BENGALLA MINE CONTINUATION PROJECT - MODIFICATION 1 STATEMENT OF ENVIRONMENTAL EFFECTS

GHD have been engaged to prepare a submission on the Bengalla Mine Continuation Project – Modification 1 Statement of Environmental Effects (SEE) on behalf of Muswellbrook Shire Council (MSC)

This report outlines the review of the SEE identifying key issues, information or assessment gaps and any other aspects which may impact on MSC's operations and the LGA.

FIGURE 4

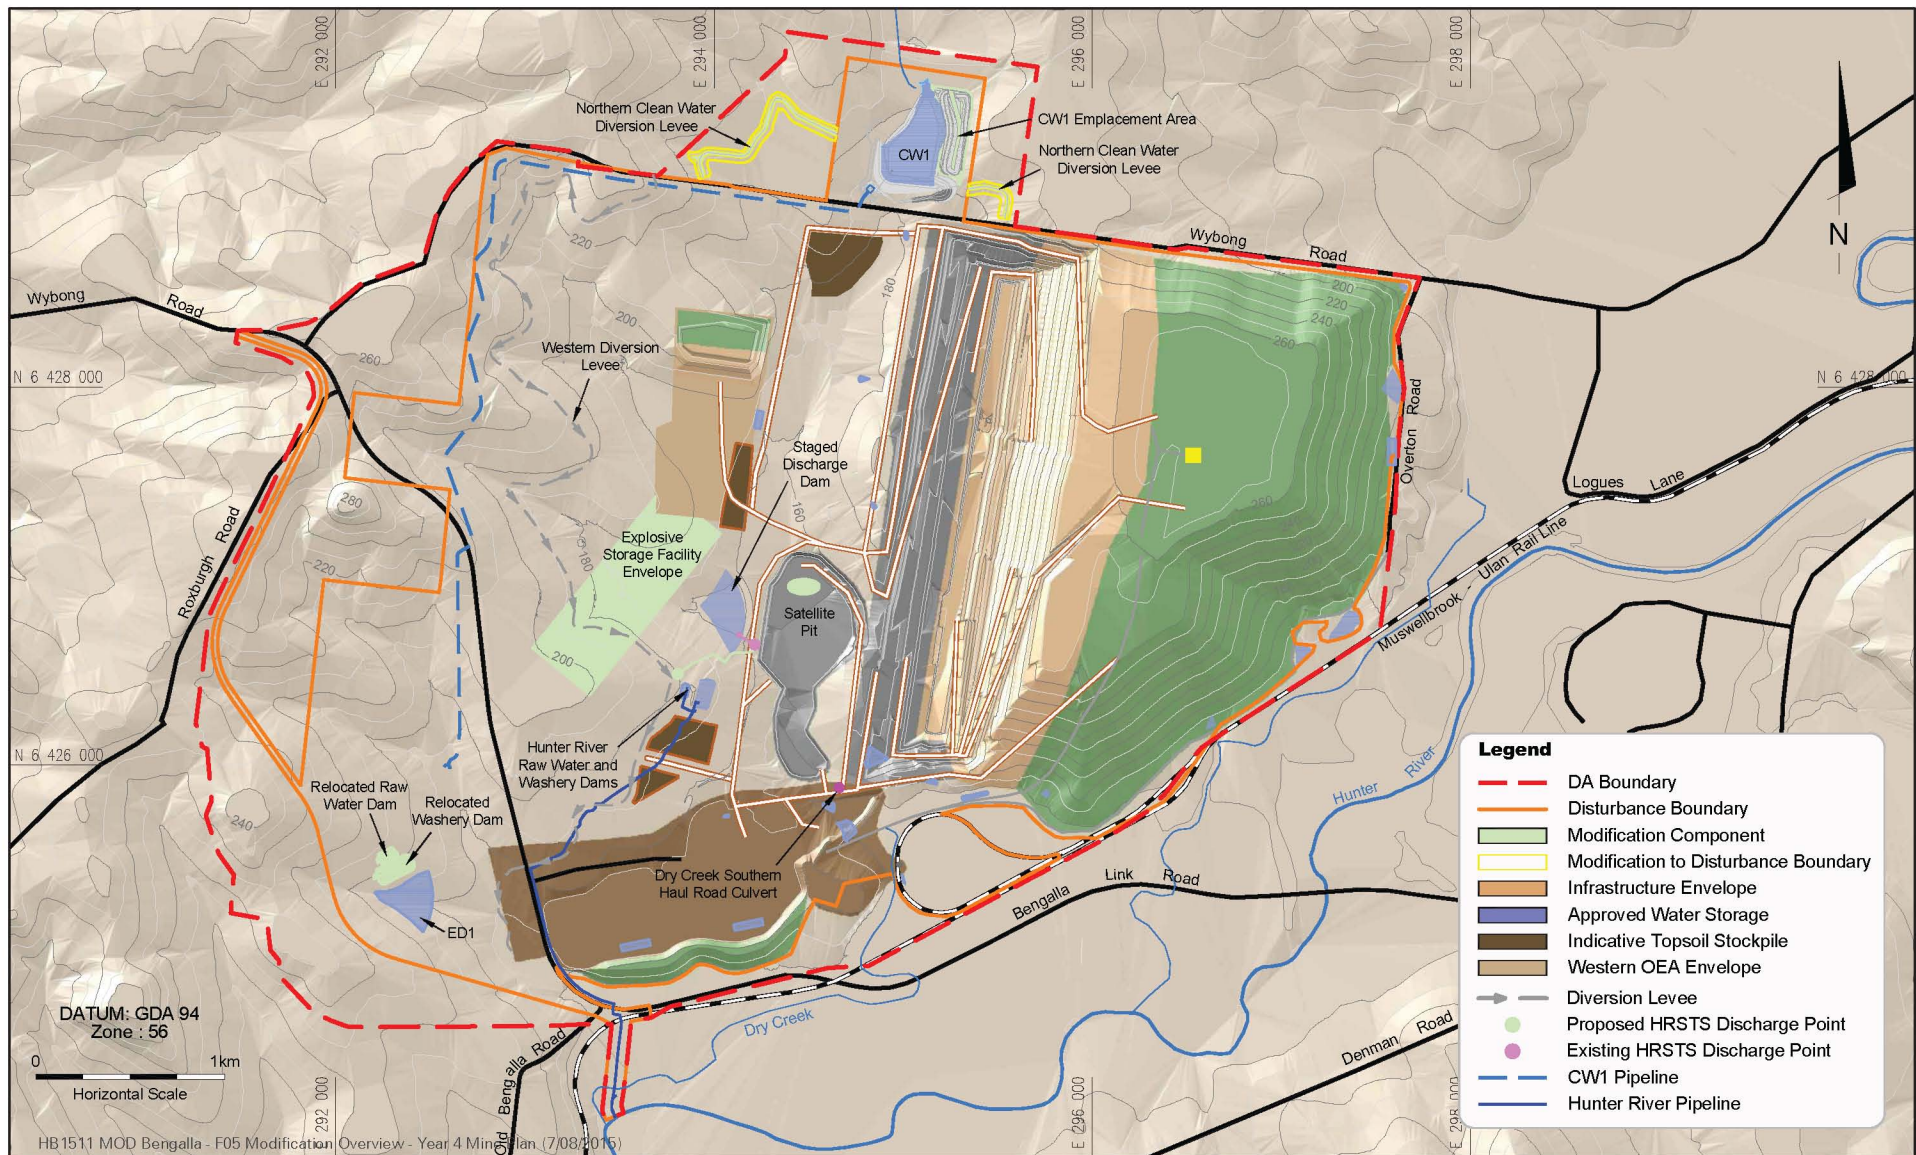
- Satellite Pit Diversion Dam is shown on Figure 4 of the SEE (Year 4 Approved Mine Plan) but does not show in Figure 5 (Year 4 Modified Mine Plan).
- Construction of Clean Water dam (CW1) at a located north of Wybong Road with pumping of water from CW1 to Dry Creek– shown on Figure 4 (Year 4 Approved Mine Plan).

- Staged Discharge Dam – shown on the Figure 4 (Year 4 – Approved Mine Plan) and retained on Figure 5. Figure 5 makes no reference to relocation of the discharge release point.

The explosives storage facility is shown on Figure 4 of the SEE (Year 4 – Approved Mine Plan) as being located on the existing OEA in a fully bunded area.

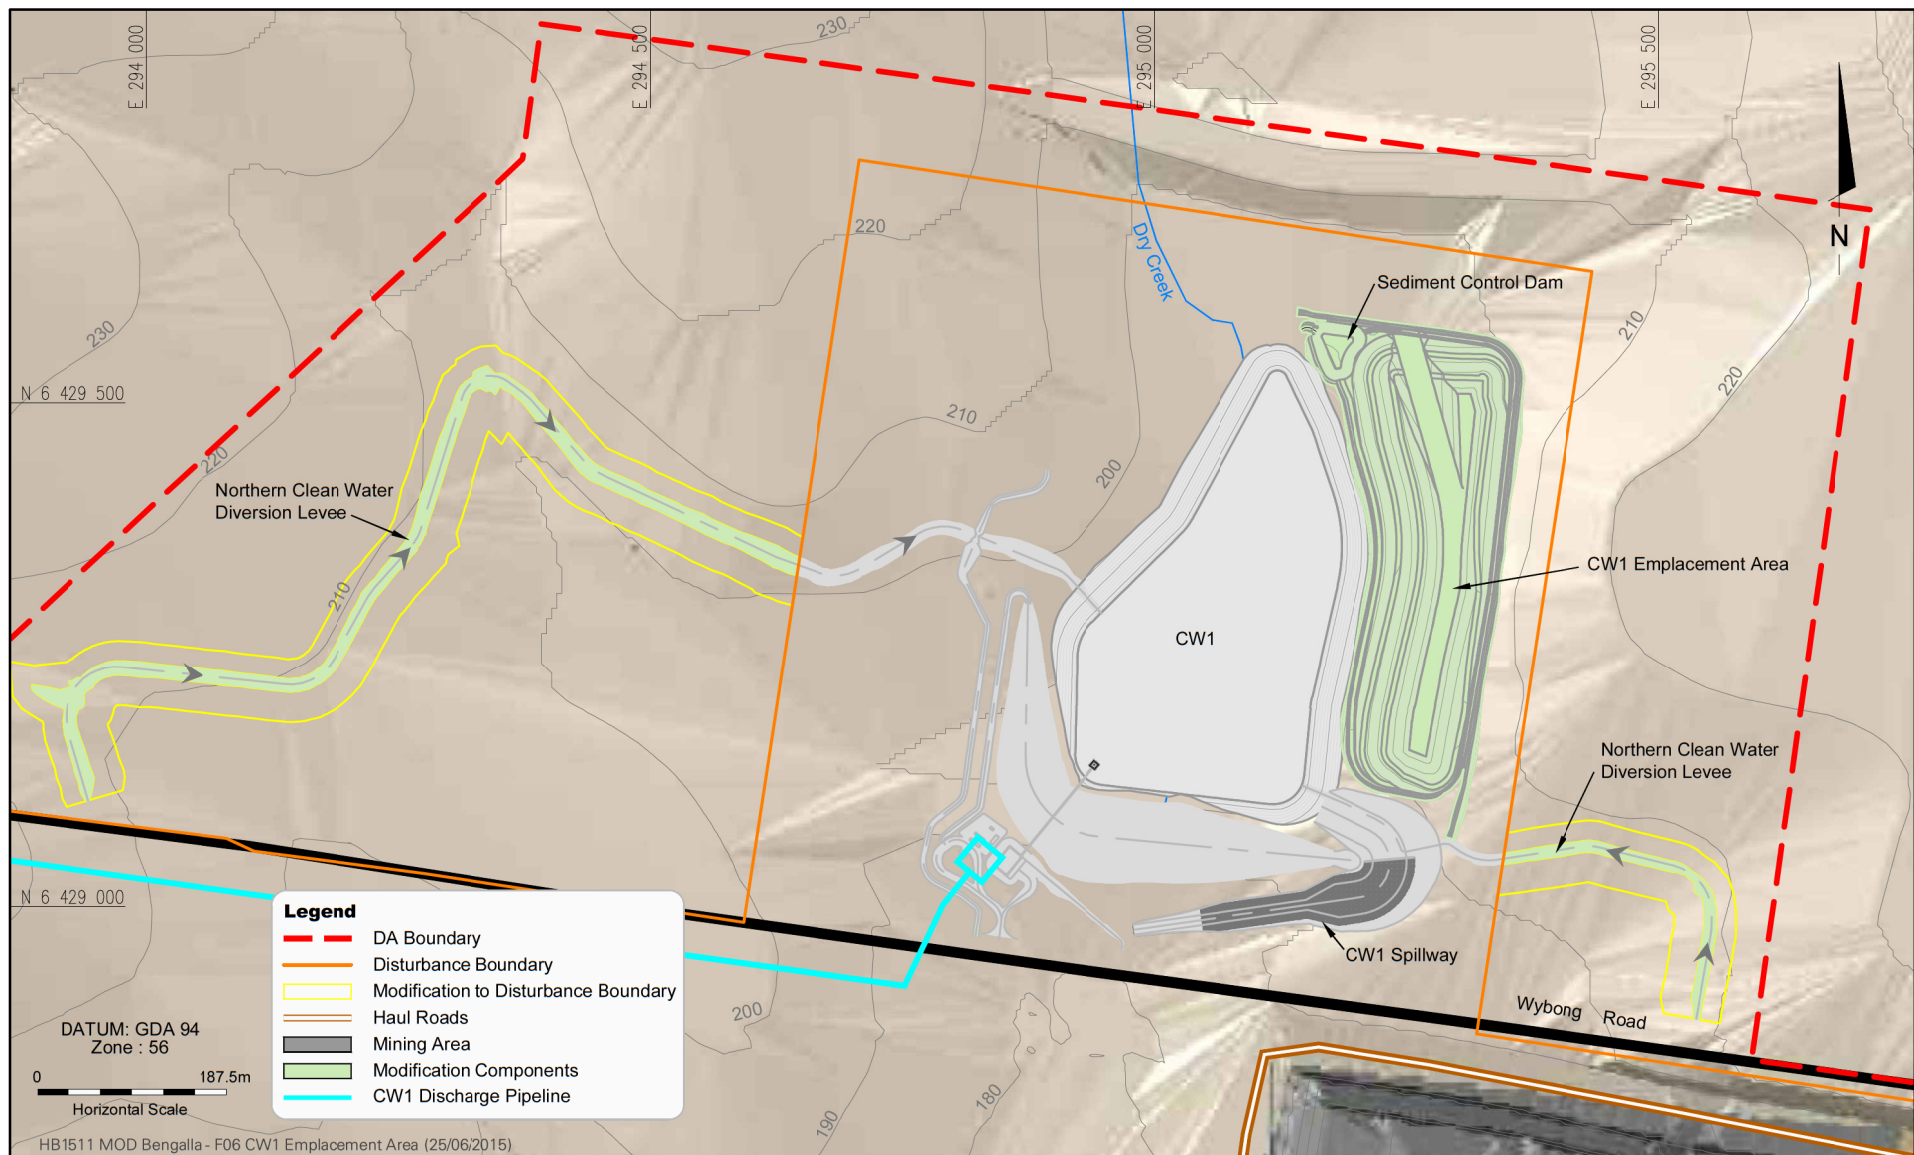
Figure 6 of the SEE provides a diagrammatic representation of the proposed CW1 Emplacement Area which is shown as being within the approved disturbance boundary. The proposed Emplacement Area is shown immediately east of CW1. Associated text within the SEE indicates the maximum batter slope for the emplacement will be 1V:2H.

Figure 6 appears to show a clean water diversion levee around the emplacement.

- The batter slopes are indicated as being up to 1V : 2H. Council is concerned about the practicality of stabilisation of this batter. A sediment control dam is shown for the Emplacement Area but the functioning of the overall emplacement stabilisation is not considered to be clearly articulated.
- Temporary erosion control measures have been described in the SEE as being implemented and maintained until the materials are relocated. The SEE provides no information on the likely life of the emplacement and thus Council is concerned about the maintenance of this area.
- Any sediment, should it enter CW1 and remain in suspension, would be pumped through the discharge pipeline prior to discharge to Dry Creek downstream of any LDP.

Council does not consider this aspect of the proposed modification should be approved. Should the Department grant this aspect of the approved modification then Council is of the opinion that stringent requirements should be imposed on the implementation and maintenance of the constructed erosion control works for this modified emplacement.
